# A303 Sparkford to Ilchester Dualling Scheme TR010036

## 5.15 Annex N: Tables Evidencing Regard had to Consultation Responses

**ANNEX N: Tables Evidencing Regard had to Consultation  
Responses**

<b>Regulation Number:</b>	Regulation 5(2)(q)
<b>Planning Inspectorate Scheme Reference</b>	TR010036
<b>Application Document Reference</b>	5.15
<b>Author:</b>	A303 Sparkford to Ilchester Dualling Scheme, Project Team, Highways England

WORK NO.17 DOWNHEAD LANE

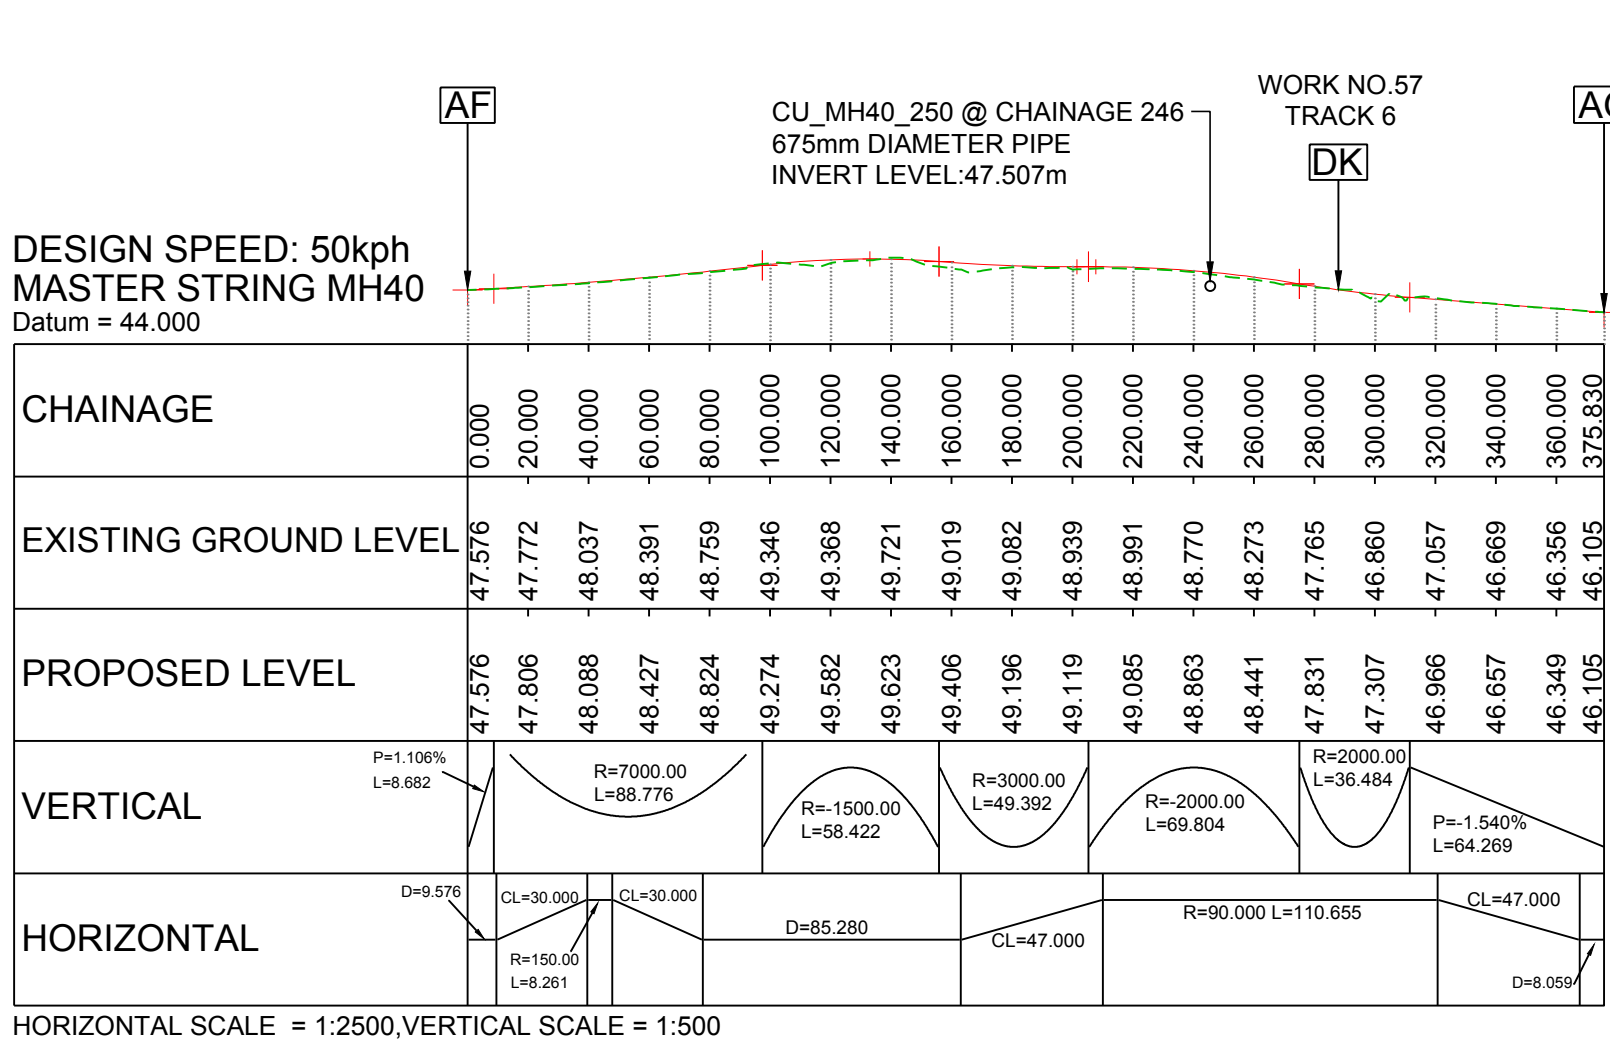
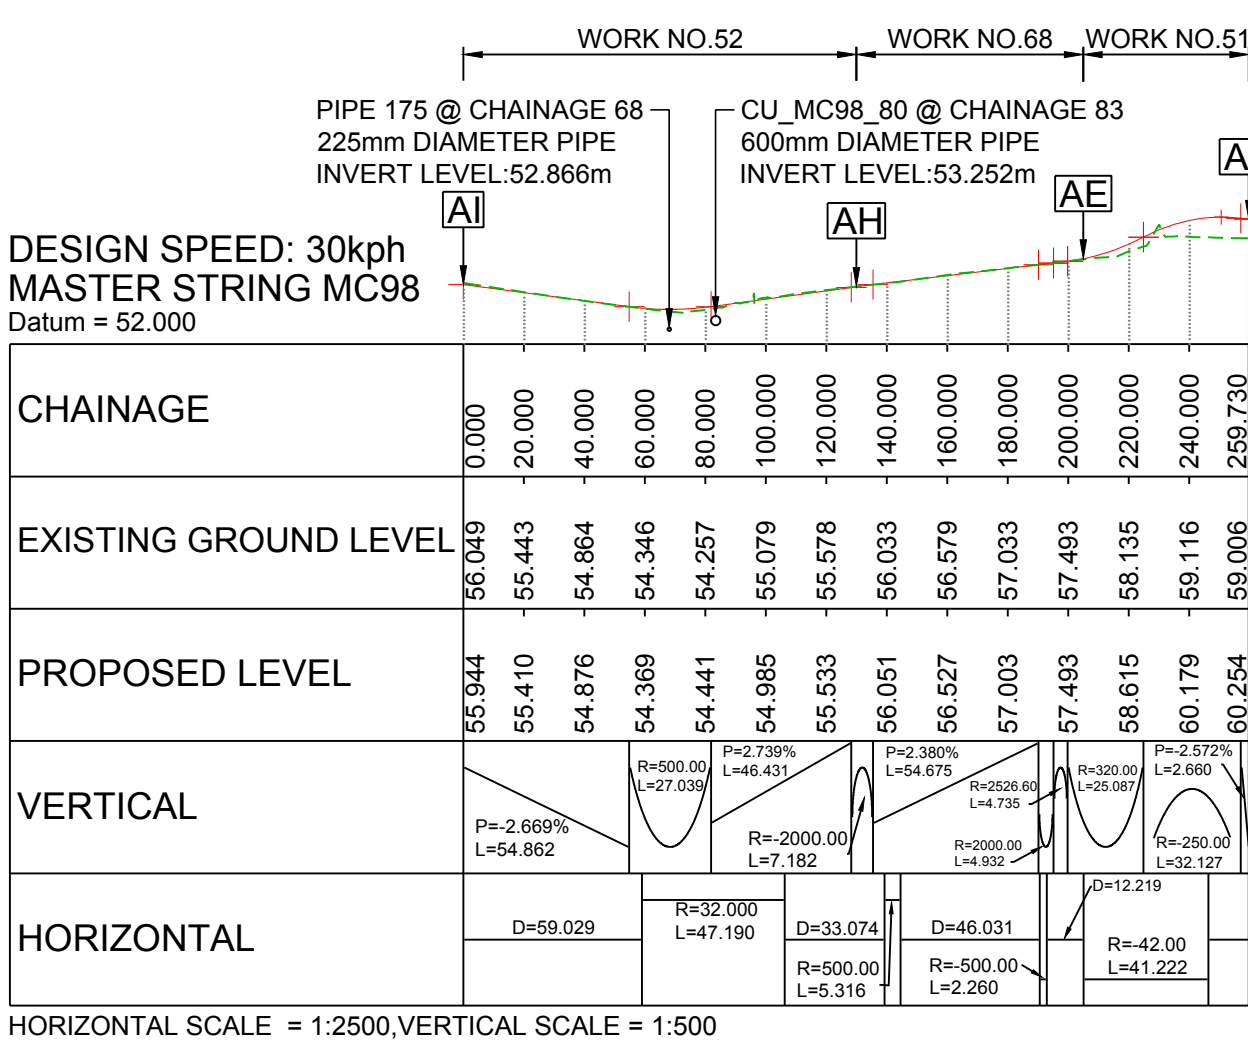
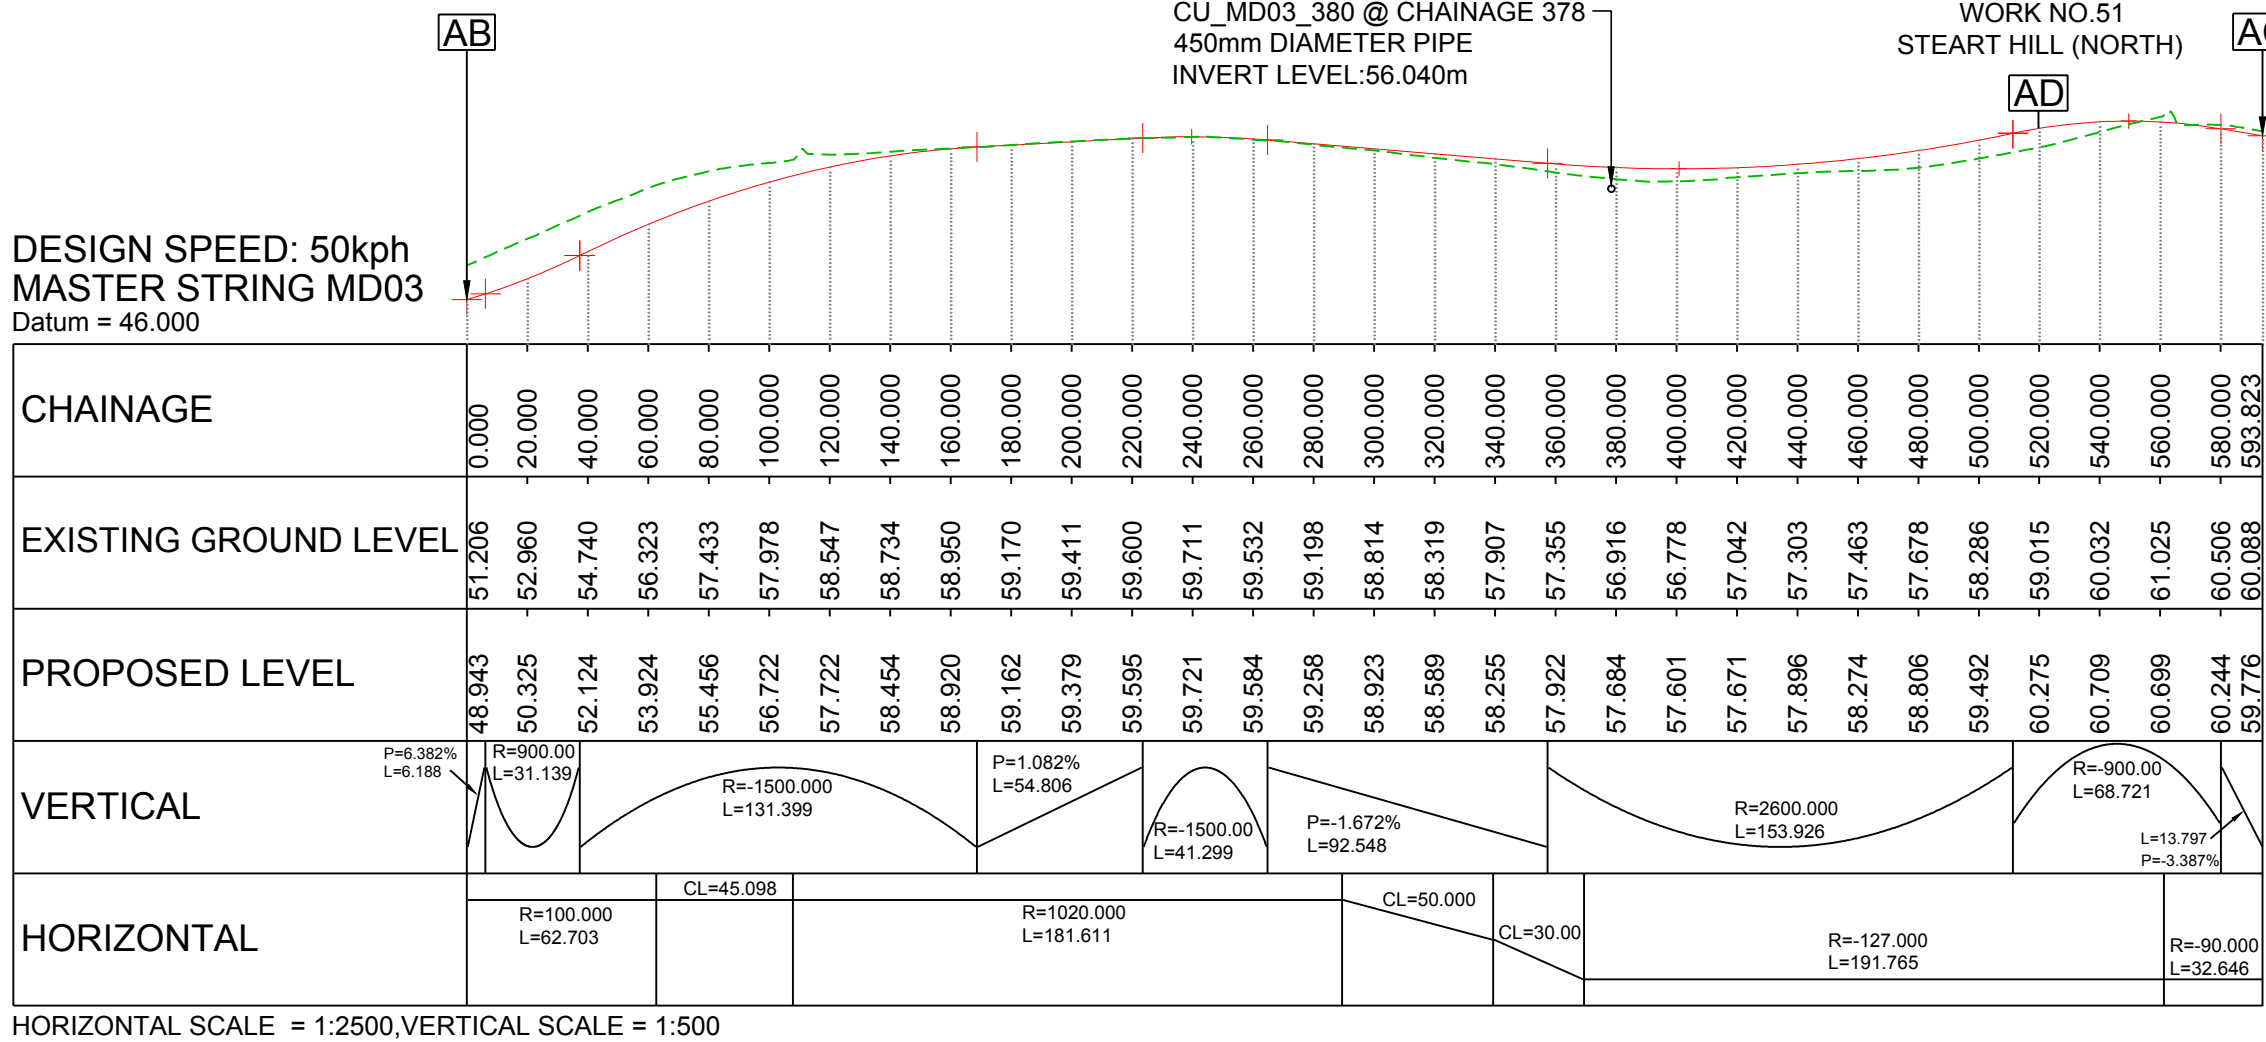
Junction layout	<i>Downhead Lane junction is too close to the exit slip of the A303, creating the potential for conflict with turning vehicles.</i>	Somerset County Council	Y – as set out in change 5 of table 4.3.1	<i>Highways England has amended the layout of this junction, creating a more simple layout overall, to address this comment.</i>
Junction layout	<i>The long, straight section of</i>	Somerset	Y – as set	<i>Highways England has amended this</i>

WORK NO.65 CAMEL HILL ROUNDABOUT

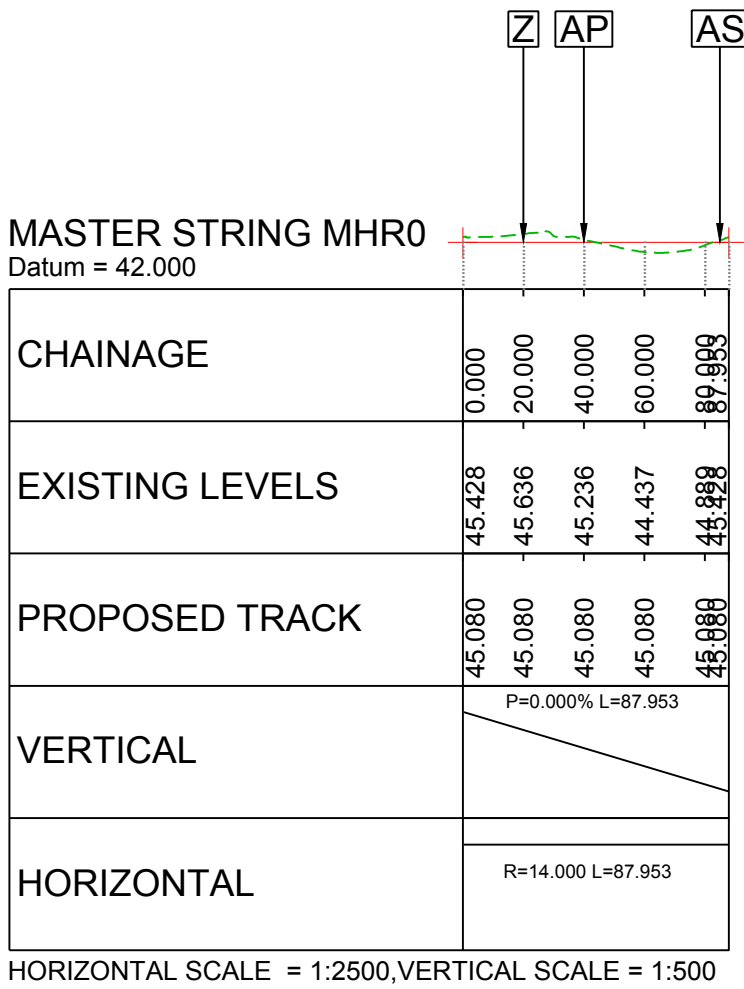
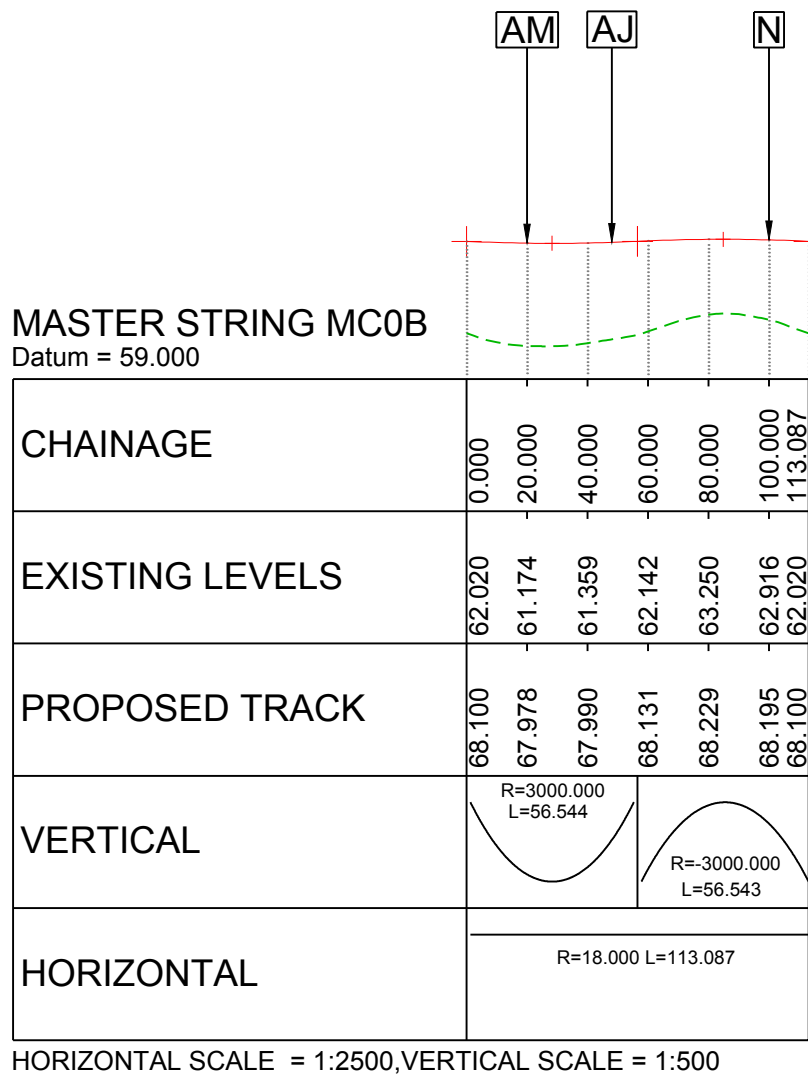
<i>Junction layout</i>	<i>It is not clear whether the Camel Hill link road is a slip road or interchange road, as it is too long to be a slip road.</i>	<i>Somerset County Council</i>	<i>Y – as set out in change 2 of table 4.3.1</i>	<i>Highways England has amended the layout of Hazlegrove junction to be more compact, featuring a roundabout on the northern side of the A303.</i>
<i>Junction layout</i>	<i>The Hazlegrove link road</i>	<i>Somerset</i>	<i>Y – as set</i>	<i>The section of the road has been</i>
